North Central Area Committee Meeting

SHD0019/22

**North West Corner of Omni Park Shopping Centre,
Santry Hall Industrial Estate, Swords Road, Santry,
Dublin 9.**

Presentation conducted by Rebecca Greene, Executive Planner, on planning application SHD0019/22 (ABP-314458-22) for the construction of 457 Apartments, Crèche and associated works.

DRAWING
Proposed Block D
North, South, West & East Elevations

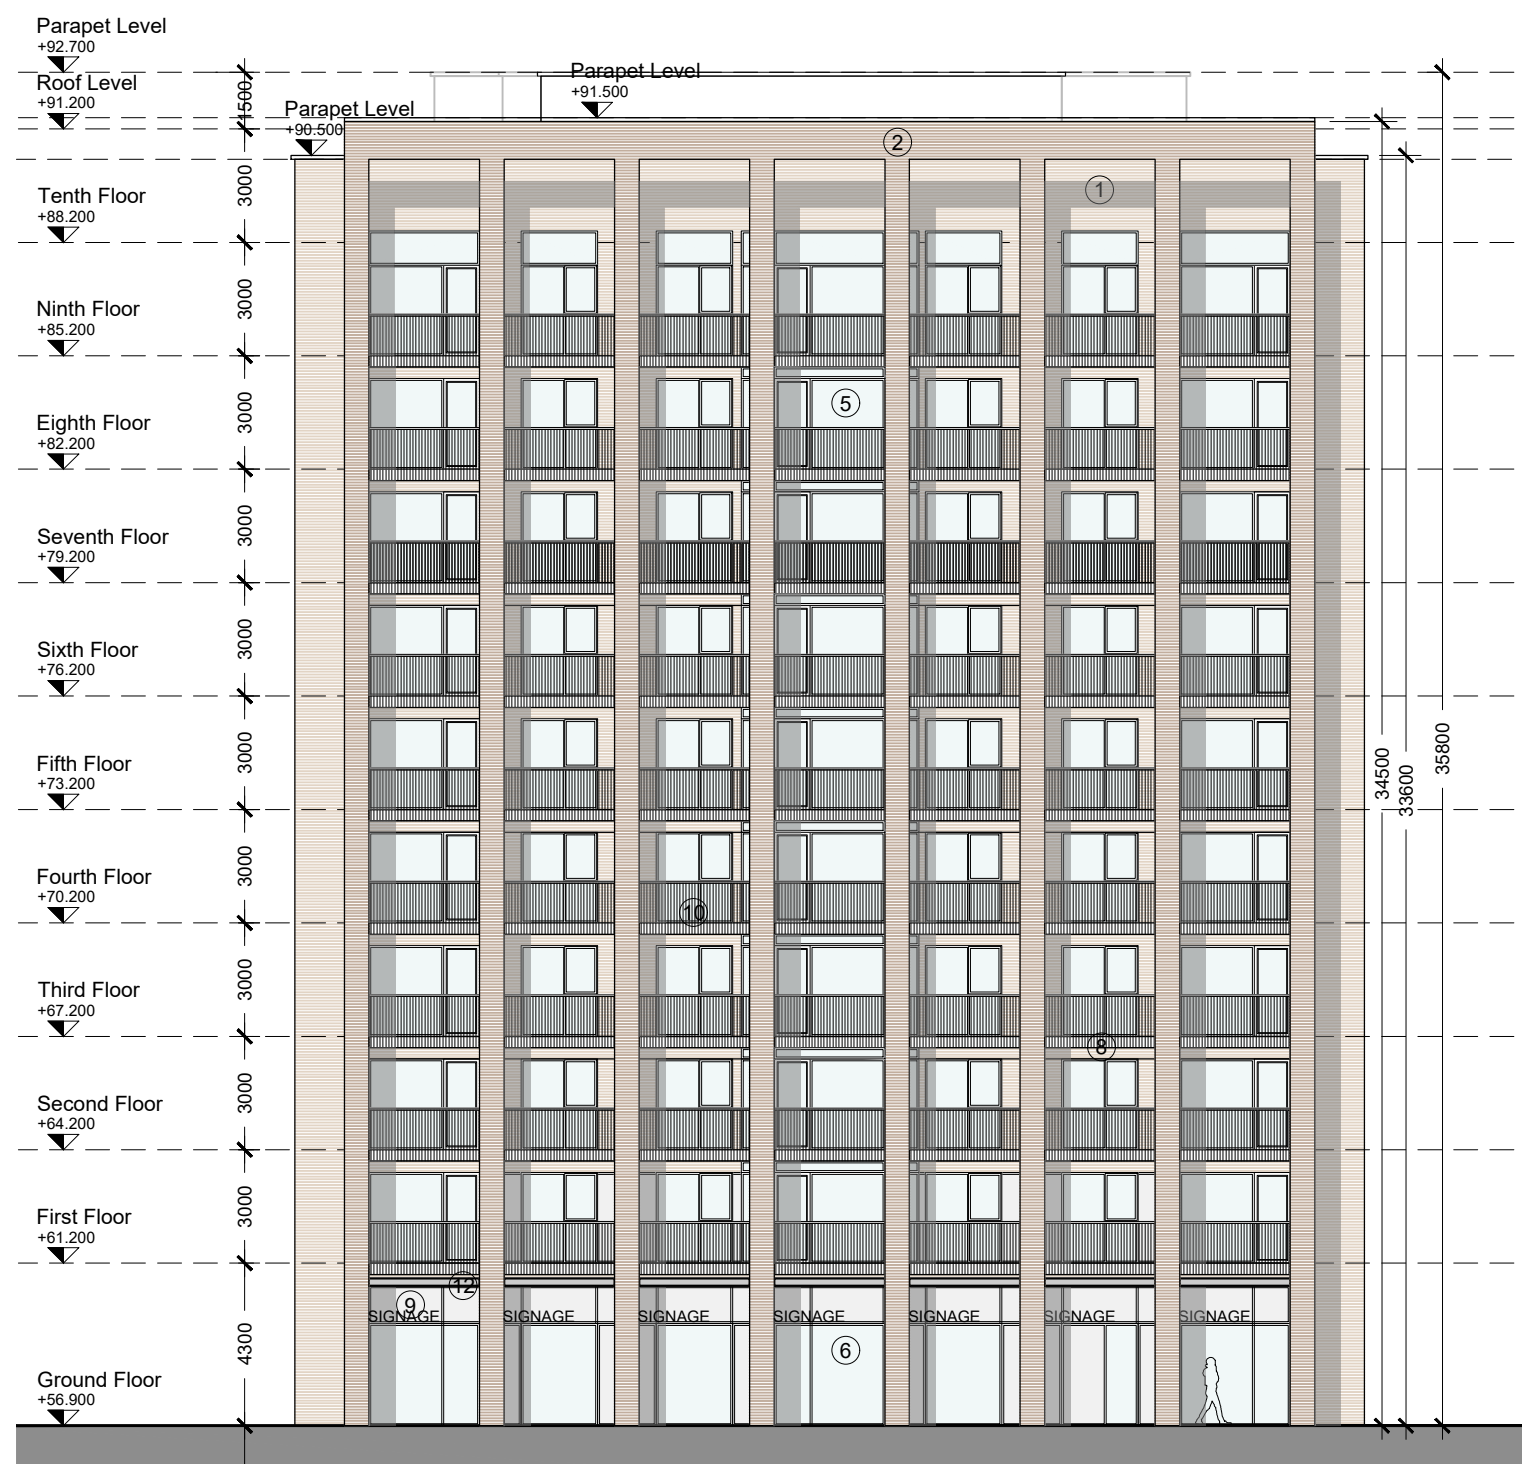
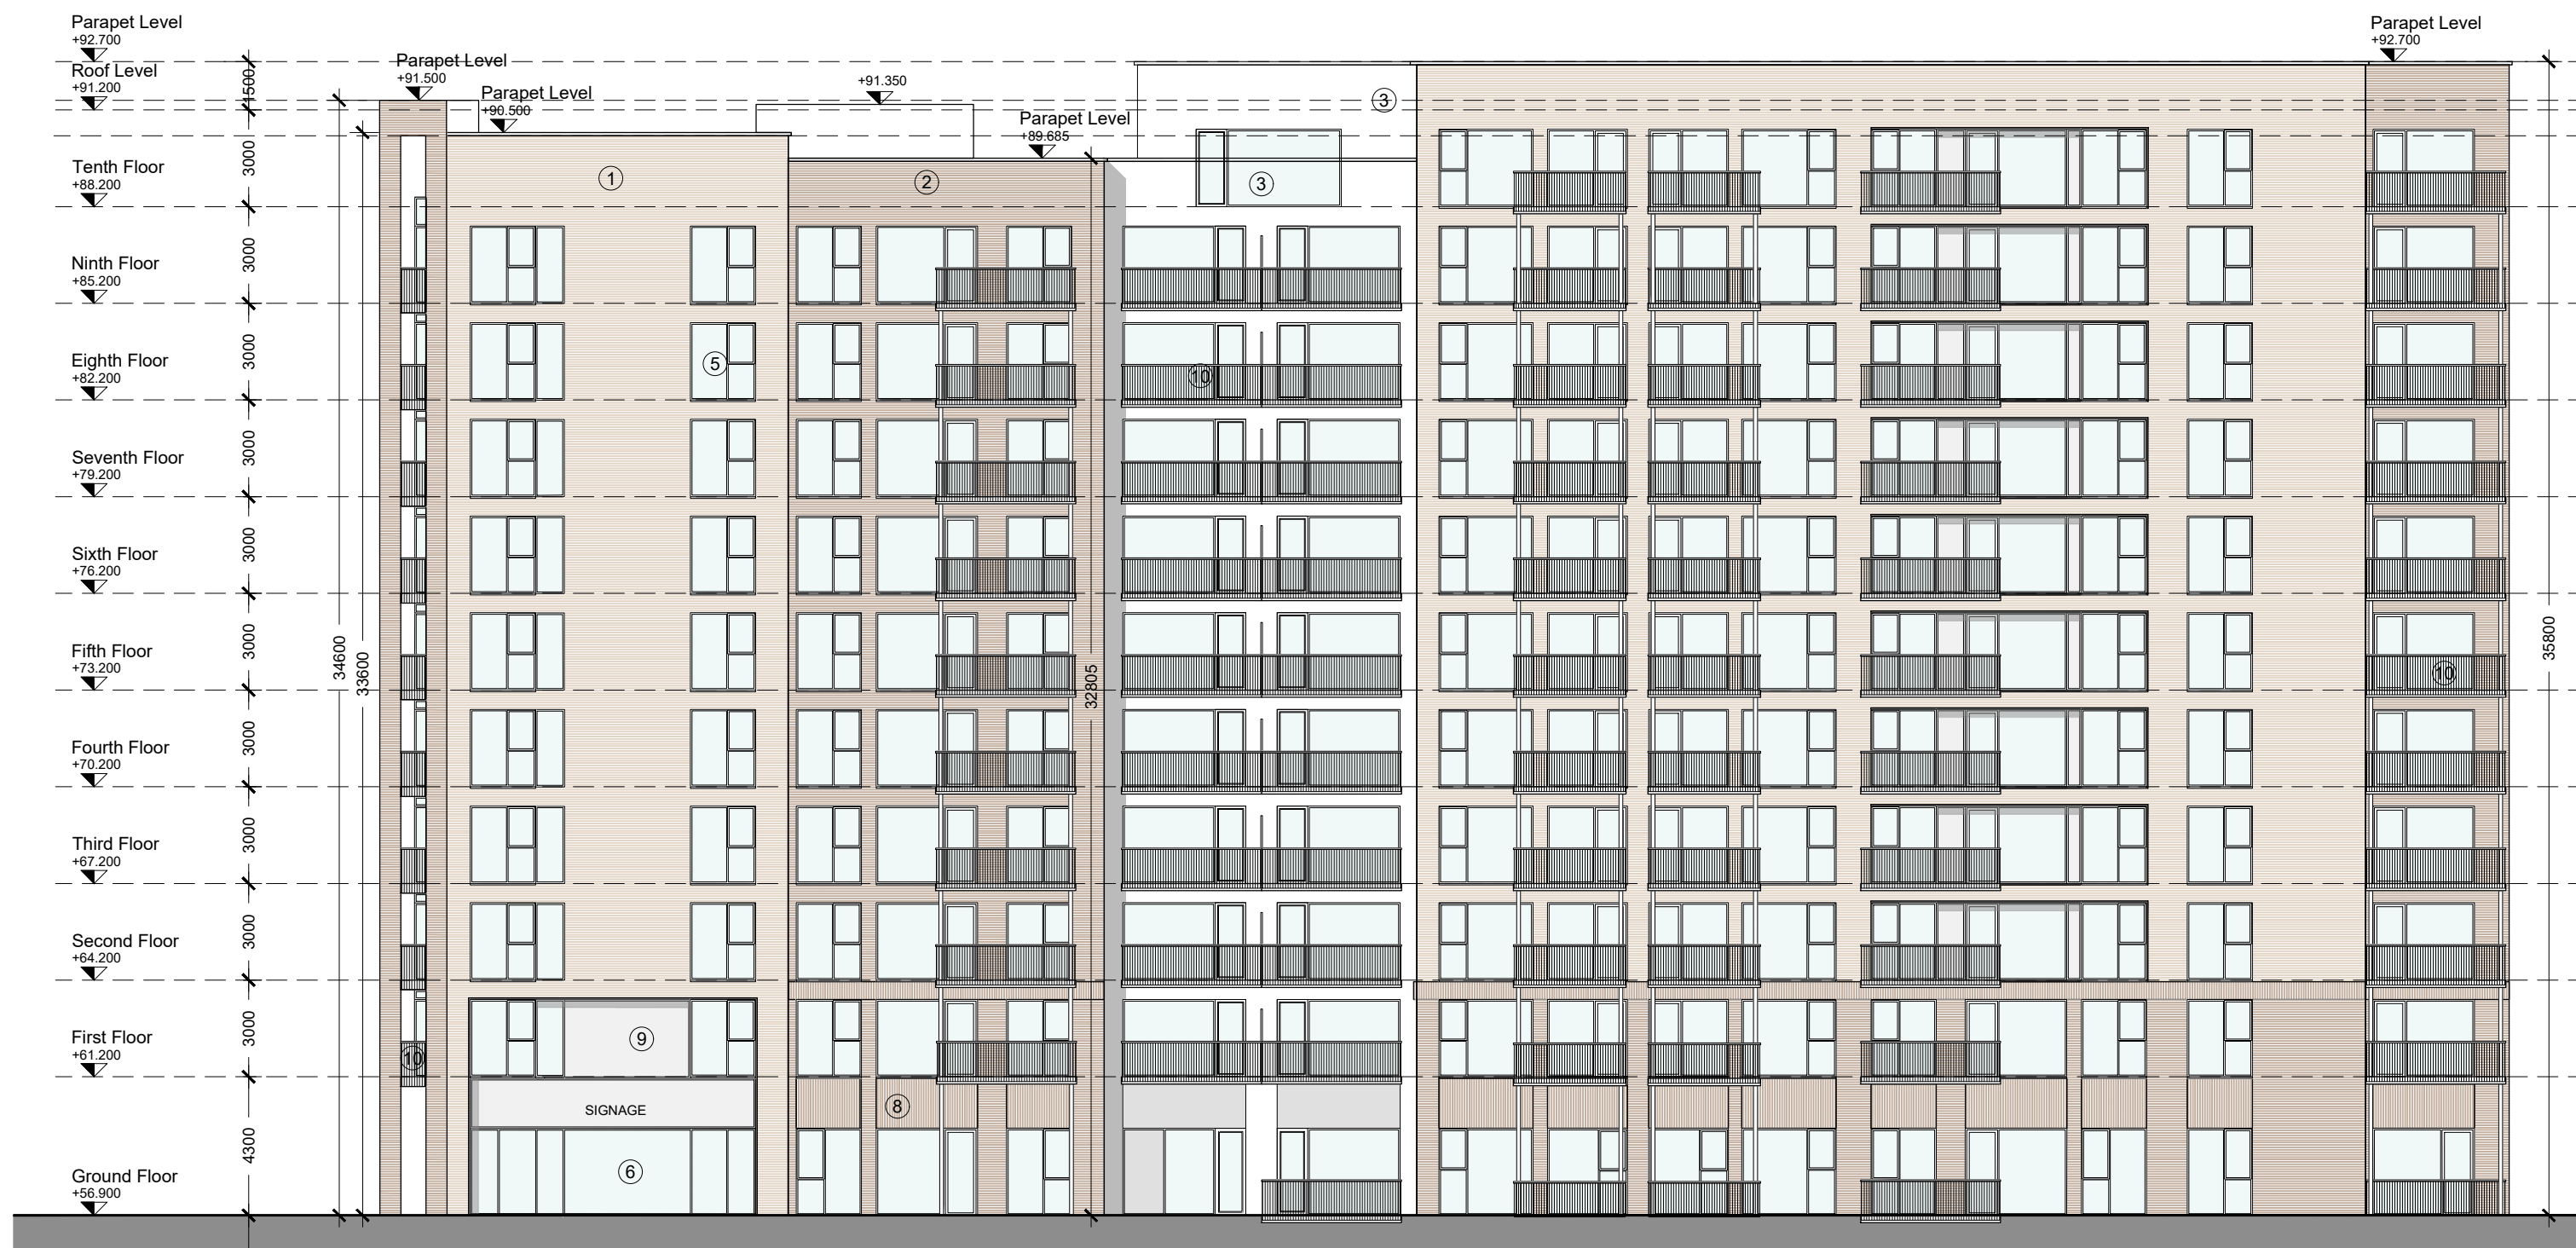
The question was also raised regarding the entrance and the access road into the site and clarification was sought by members as to whether these were actually ingress roads or if this was a new entrance above Block D and will it have Traffic Light functionality.
